Application No: FG/57/22/PL  
Site Address: 12 Little Paddocks Ferring BN12 5NJ  
Description of works: Demolition and erection of 1 No new dwelling. This application is in CIL Zone 4 and is CIL Liabe as new dwelling.

Thank you for your internet representation made on 8th May 2022 which has been recorded as an objection with the comments as follows:

DRAWING No.
**Drawing 1
Existing & Proposed
Floor Plans & Elevations**

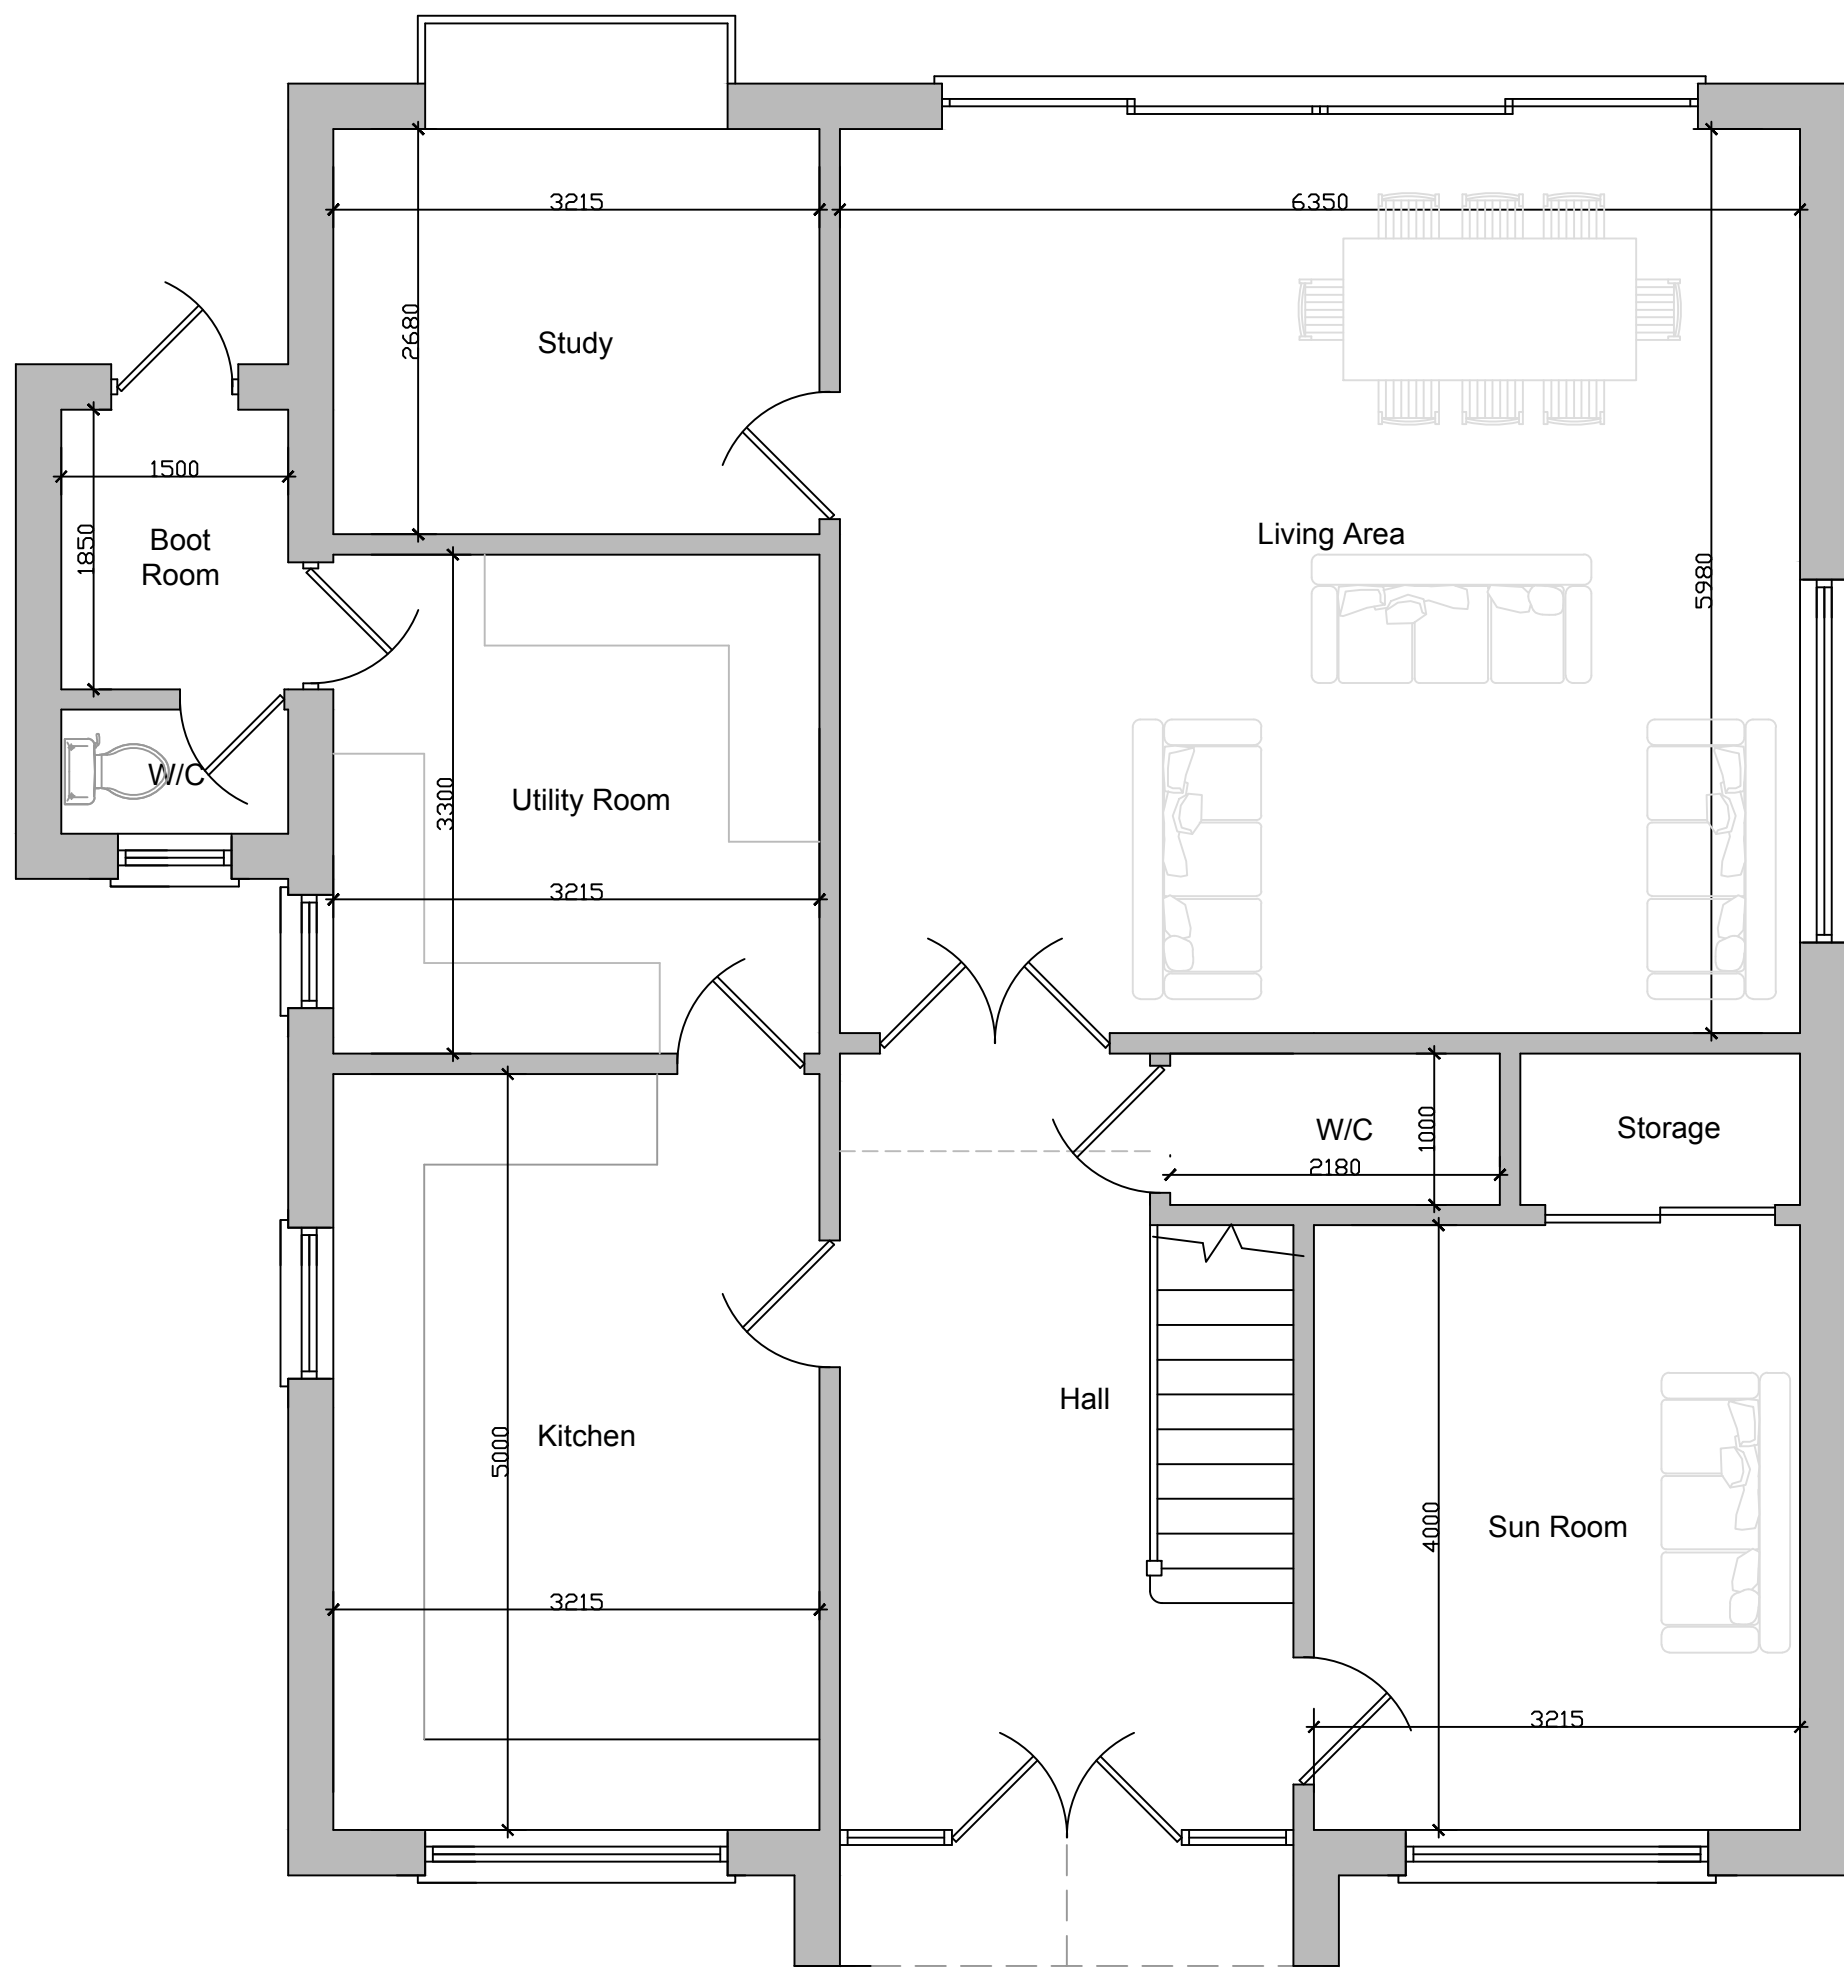
From all aspects the character of the existing bungalow will be completely lost. The scale, form and design of the proposed structure is inconsistent with that of other properties in Little Paddocks. Accordingly, the proposed structure fails to reflect its setting and the existing character and sense of place of the area is not respected. The frontage especially is completely inconsistent with that of other buildings in the vicinity.
